**Consultation Response from KC,
Lead Local Flood Authority**

2023/92448 Former Cooper Bridge Water Treatment Works, Leeds Road, Mirfield, WF14 0BT

Outline application for erection of B8 industrial unit with details of access points only

Date Responded: 12th April 2025

SITE PLAN

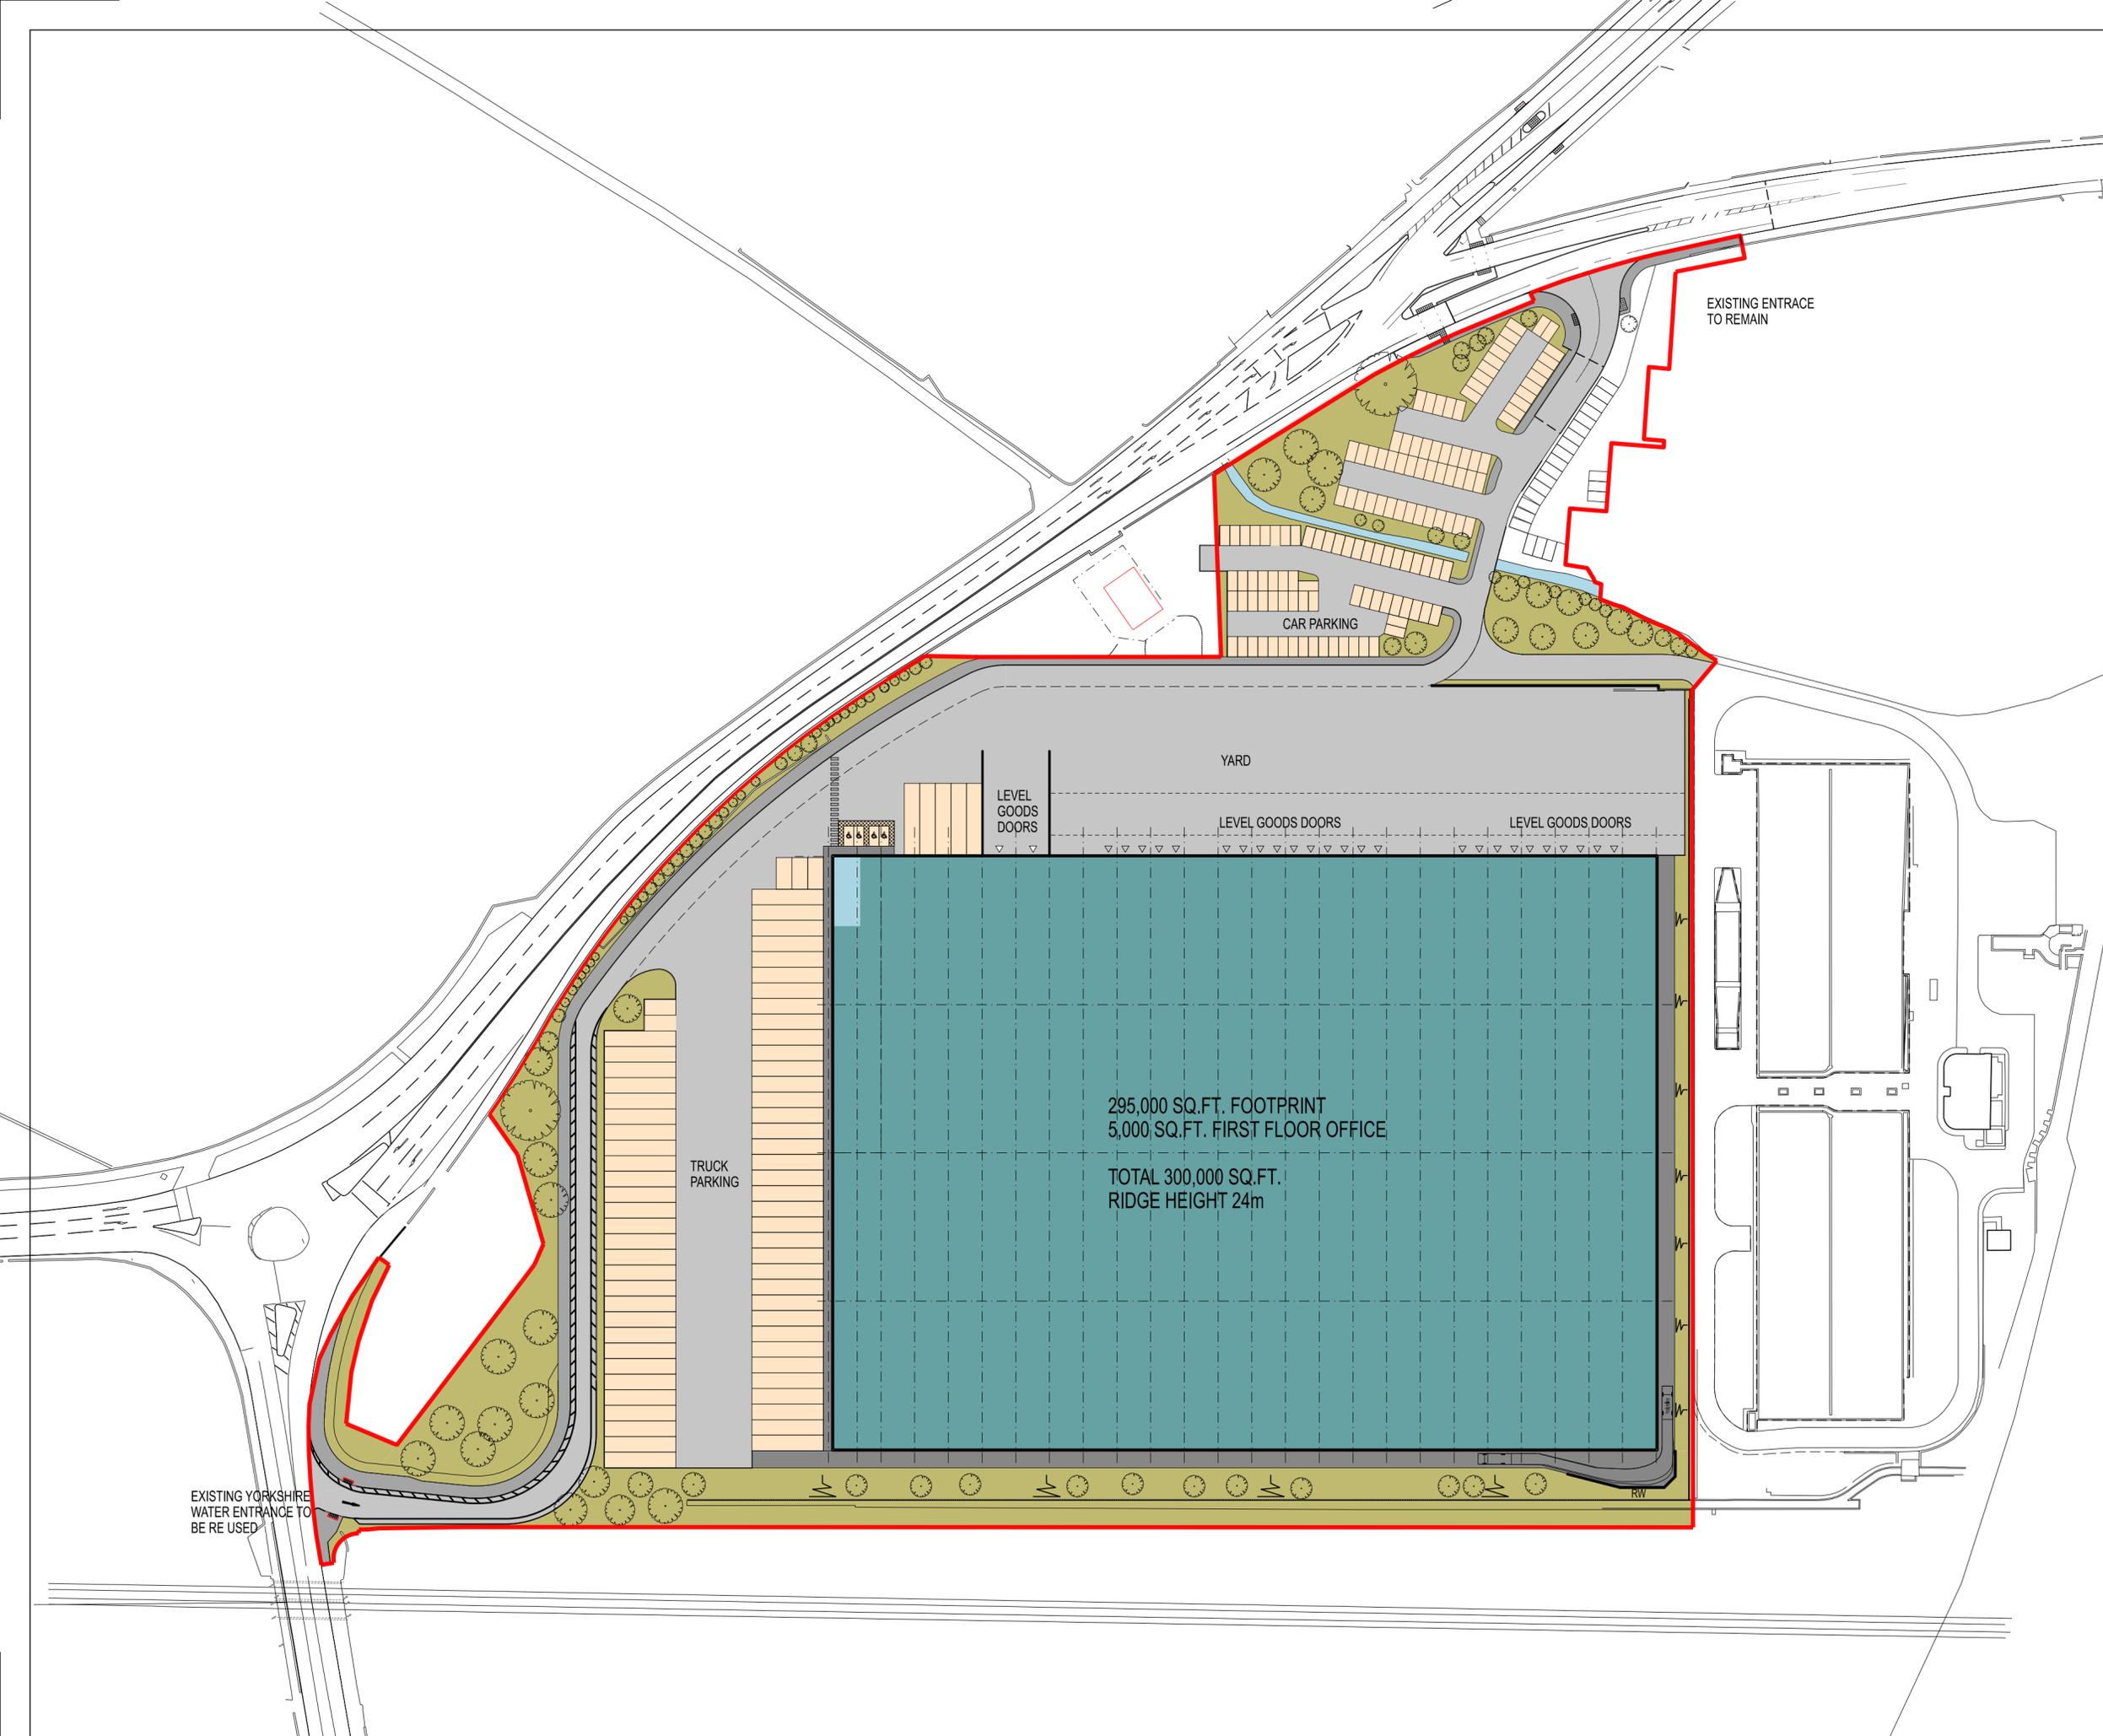
Watercourse channels will also become functional floodplain and a stand off distance does also. This has an effect on Nun Brook, as it enters site where a car park is proposed.
